10 May 2019

Planning reference: FG/42/19/HH
22 Singleton Crescent, Ferring BN12 5DG

Single storey front extension, side extension, conversion of garage to habitable use and conversion of roof space to habitable use to include a rear dormer and 3 front roof lights.

AR-138-05

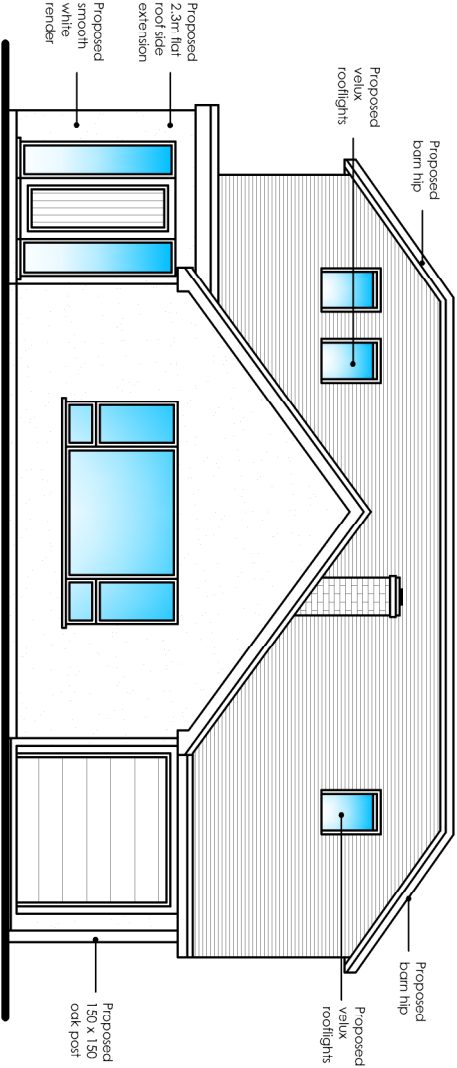
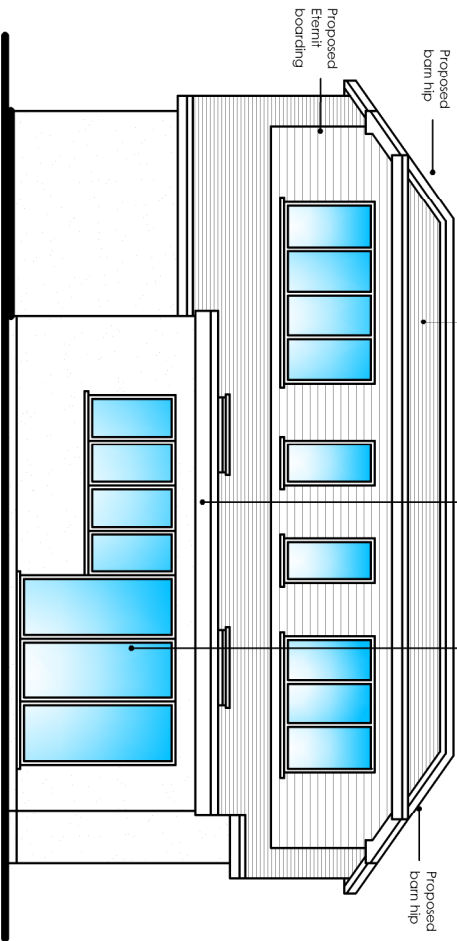
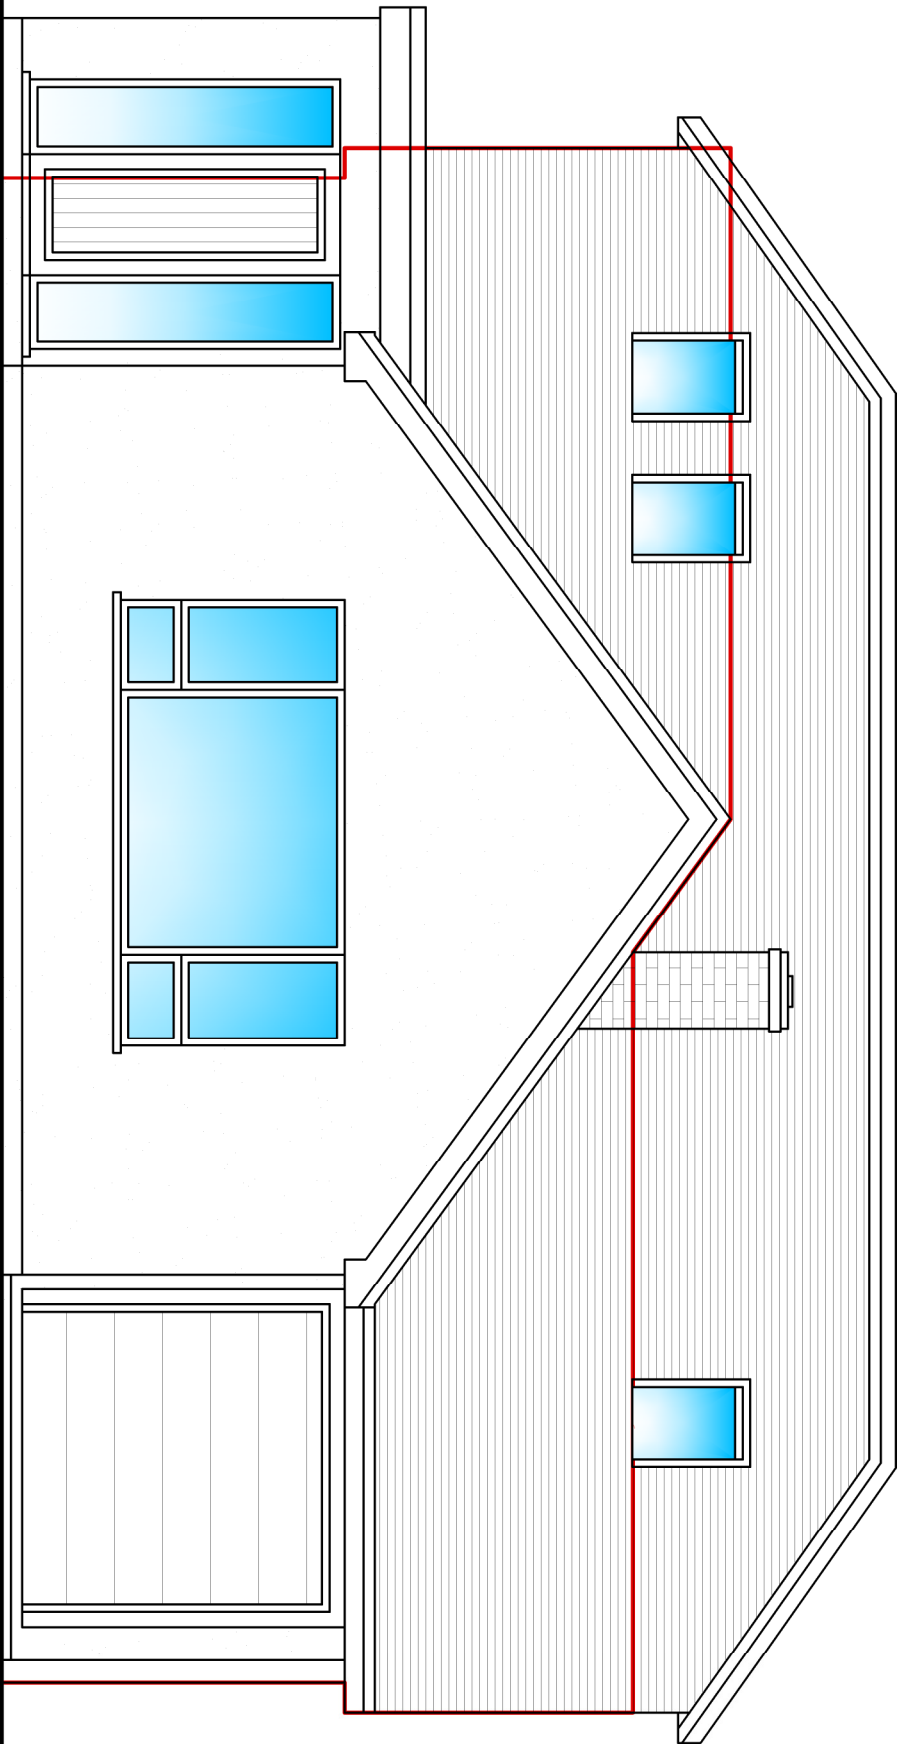
Planning notes 1 "The proposed design replicates the original house design opposite No 27" (we assume this is an error and should read No 22)

The property shown in the photograph is a bungalow not a house, as are all the immediate properties to either side and opposite No 22. The scale of the proposed development, the lifting of the ridge height and the extension of the roof pitch to the front and rear of the property will dominate all the immediate surrounding properties and fundamentally change the street scene. You can see from photographs 1.1, 1.2, 1.3 that no other bungalows in the immediate area have had their roof line altered and this section of Singleton Crescent retains the original street scene as set out when the estate was built.

Planning notes 2 The loft conversion of No 28 was achieved without the need to make alterations to the roof pitch or height, therefore retaining the original design, size and shape of the building from the street (the only change to the front elevation of the property being the insertion of roof lights). The same cannot be said for this proposed development.

Planning notes 3 No 27 is situated on a corner plot on the outside curve of Singleton Crescent. Although now a large dominant property the building's position on a large plot and within the estate minimises to some degree the effect it has on the surrounding properties. The property is also screened by several mature trees, including a very large weeping willow. The same cannot be said for the proposed development of No 22 which is currently a small bungalow on a narrow plot set in a row of similar properties and if the current plans were to be approved will become a large house that will overshadow the surrounding properties, in particular the two neighbouring bungalows.

The proposed increase in the ridge height by up to 1.5 metres to a level in excess of 5.7 metres and the subsequent moving forward of the entire front facing slope of the roof by up to 3 meters as outlined on the plans will reduce the level of daylight across our bungalow. The detrimental impact on the light levels on our south elevation, in particular our dining room will be even more noticeable in the autumn and winter months when the sun is considerably lower in the sky and light is at a premium on that side of our property. Photograph 2.1 shows the current roofline of No 22 as viewed from our dining room.

- The plans indicate that any new or altered exterior walls on the ground floor will be finished with smooth white render to match the existing structure as you would expect. We are however concerned that there is no mention on the plans of a colour for the proposed cladding on the dormer and gables. If a dark grey (such as the colour on the garage door of No 22) were chosen it would make these areas even more overbearing, especially as all the gables are currently smooth white render in keeping with the rest of the bungalow. As No 28 has been used as an example we would request that the use of the same colour cladding (or a lighter if possible) as No 28 should be made a condition of planning consent.

PROPOSED FIRST FLOOR PLAN 1:50

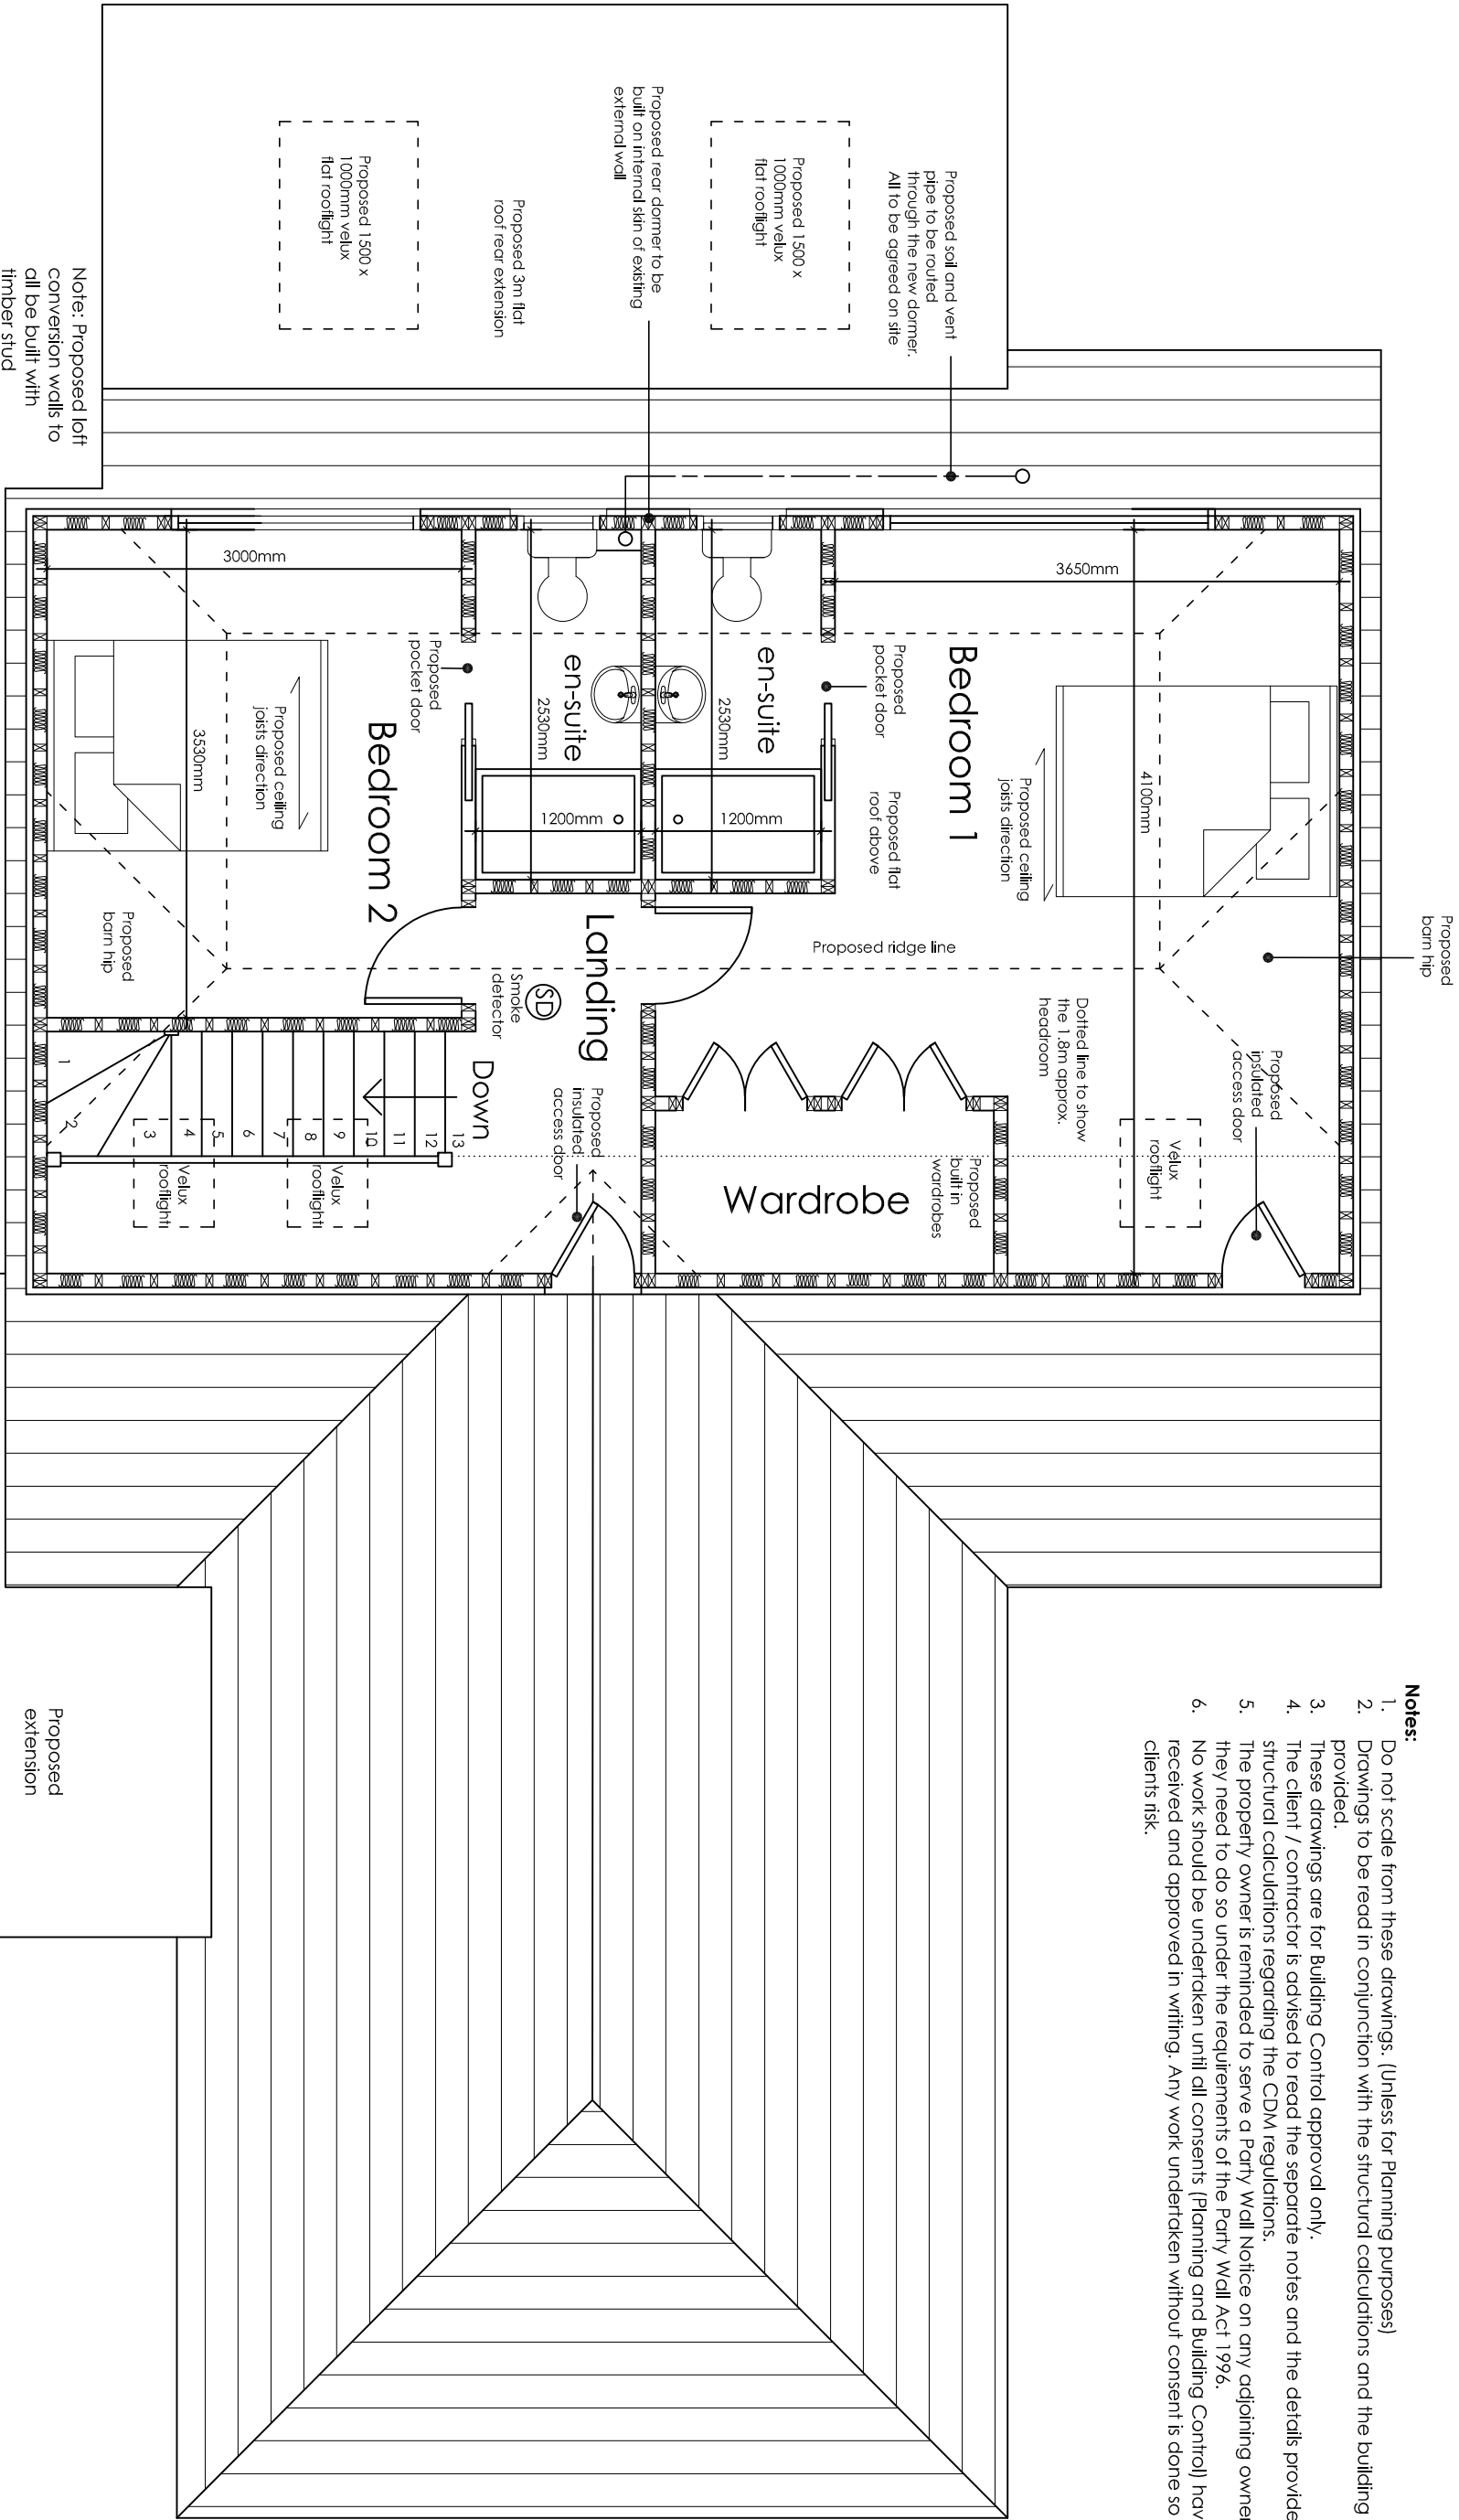
Currently our back garden and those of our neighbours are secluded and as the dwellings are single storey they afford a high level of privacy. Should consent be granted for large dormer windows to the rear of No 22 this will affect the privacy of the neighbouring bungalows particularly that of No 20.

PROPOSED GROUND FLOOR PLAN

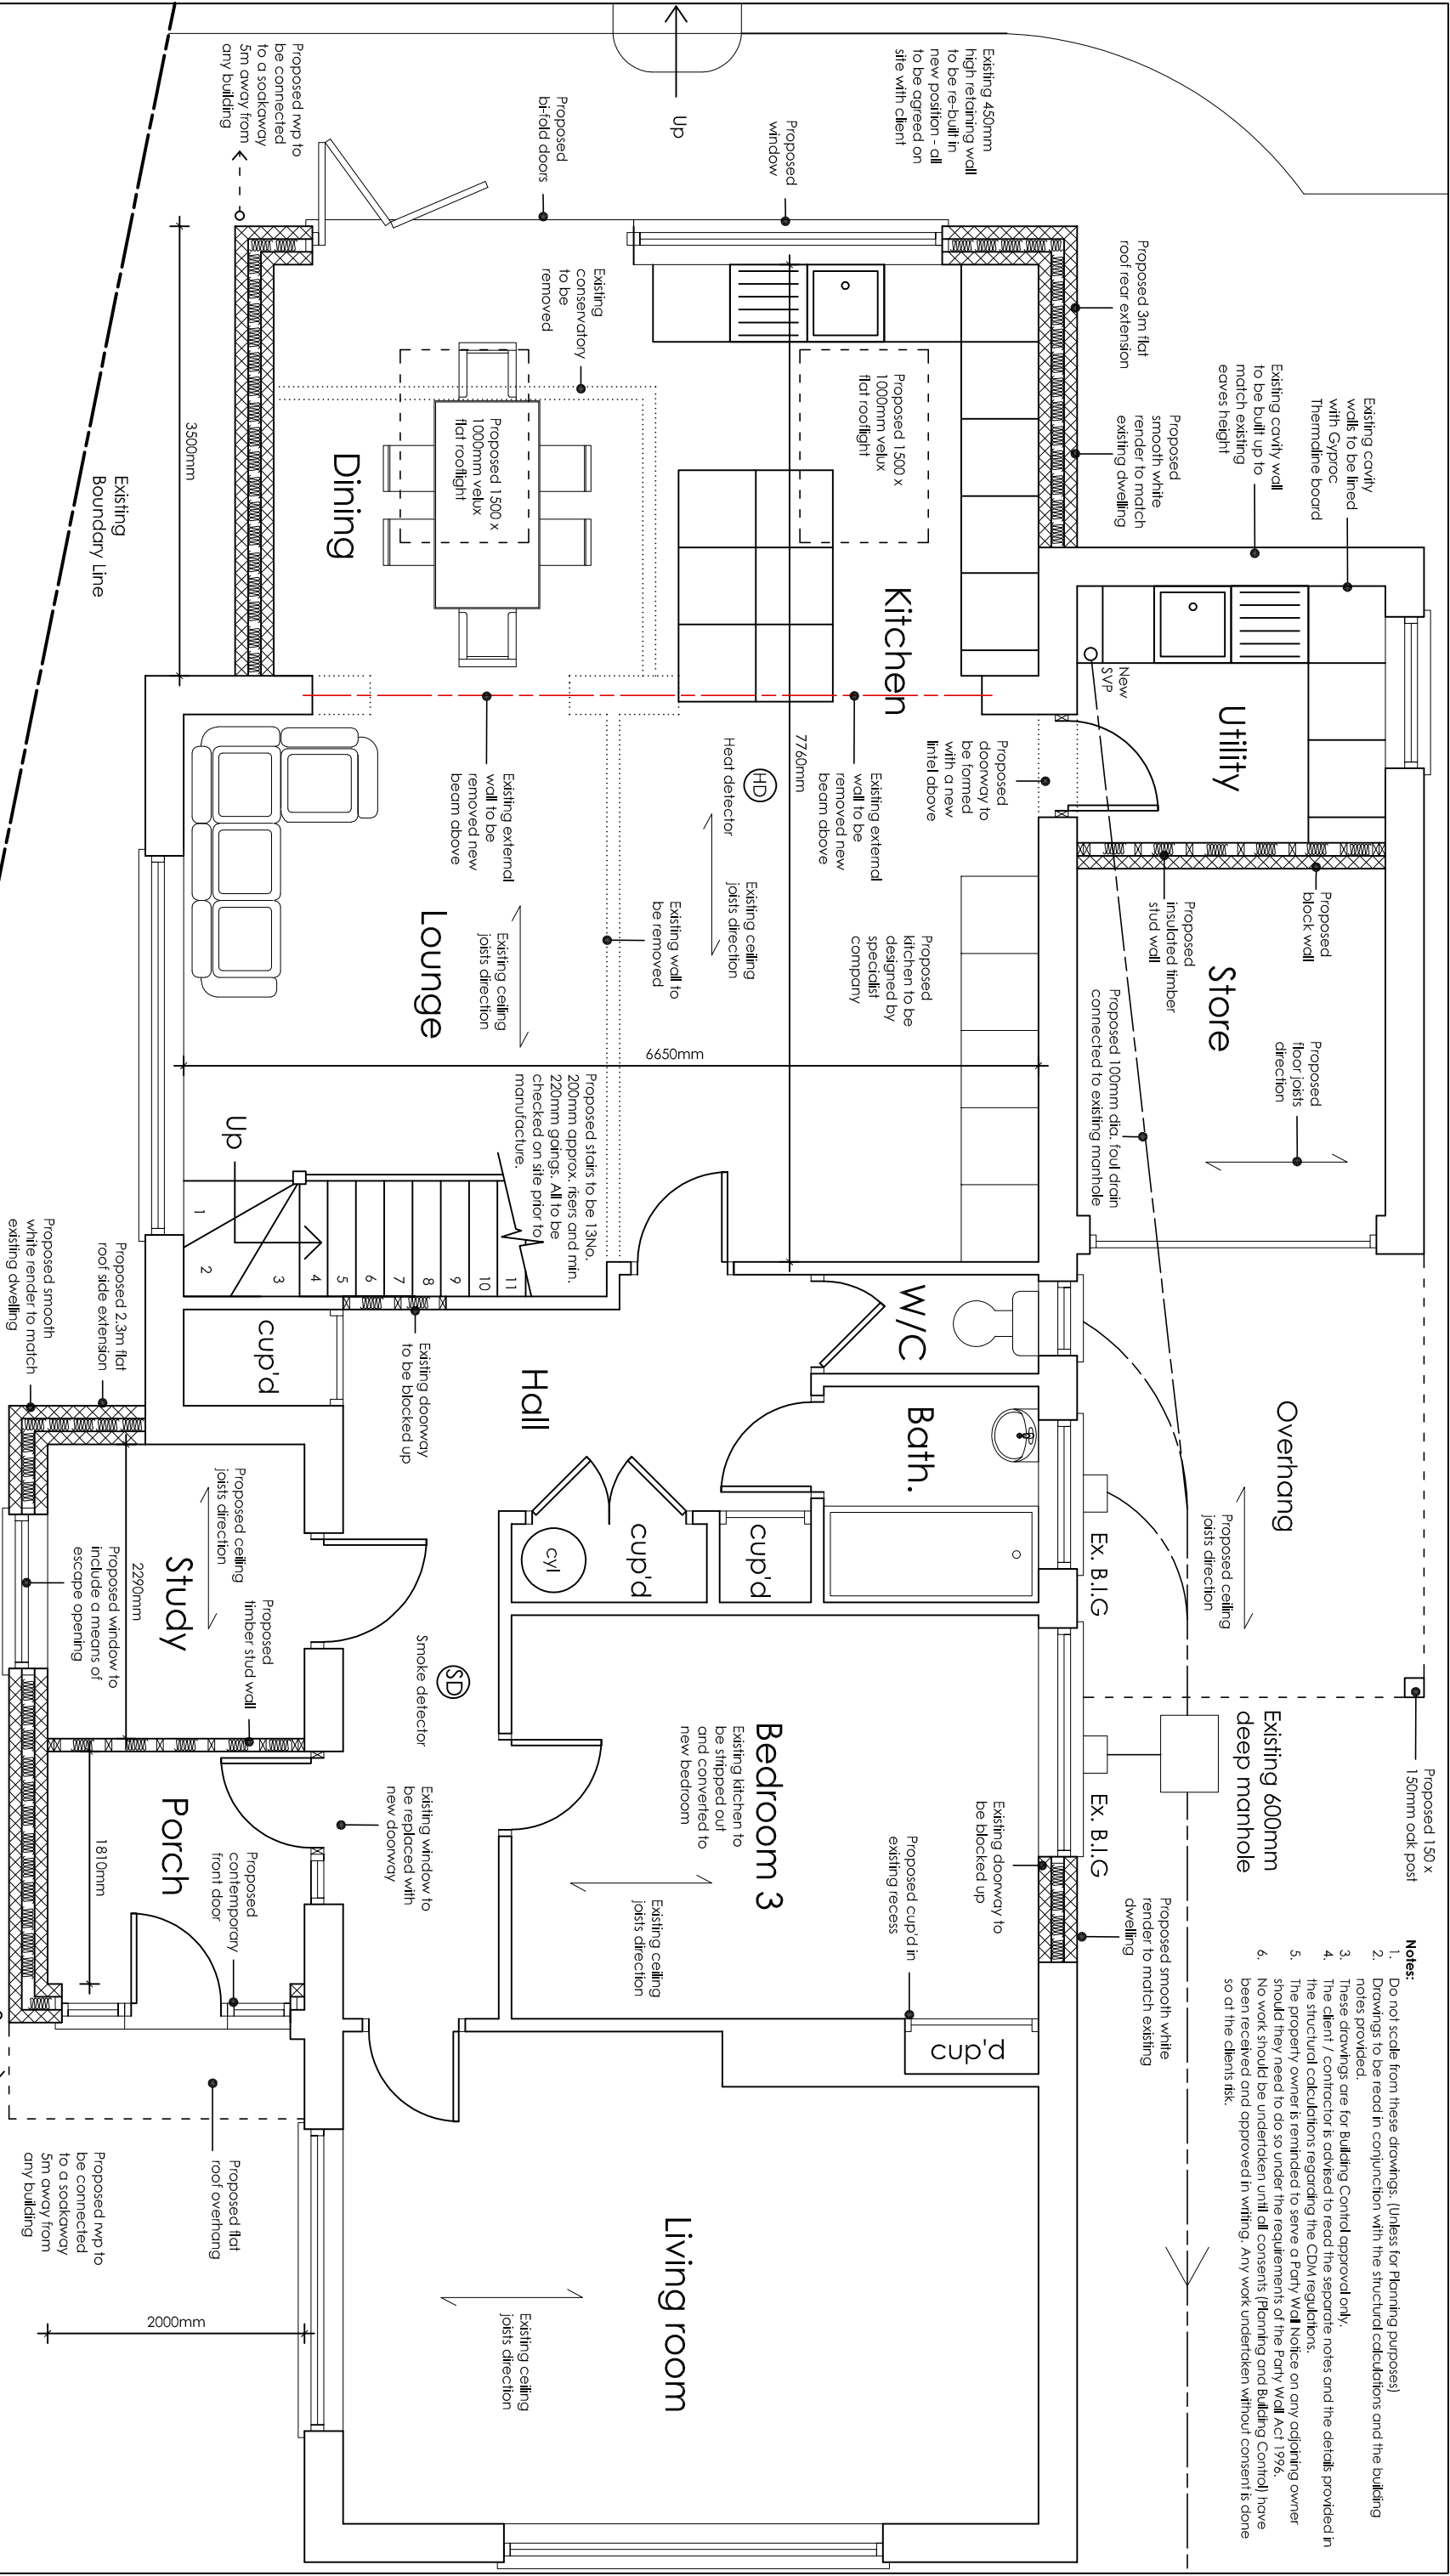
The above taken from section 4 of the planning application describes the proposed works as a single storey front extension which is not reflected in the plans and there is no mention of the single storey rear extension that is shown on the plans. Perhaps this needs clarification.

From the plans it would appear that the proposed rear corner of the study would be less than a metre from the existing boundary line. Mr Wilmot has already told us that he would be willing to move the window in the study to the rear facing wall allowing privacy for both properties and this is definitely something we want to achieve.
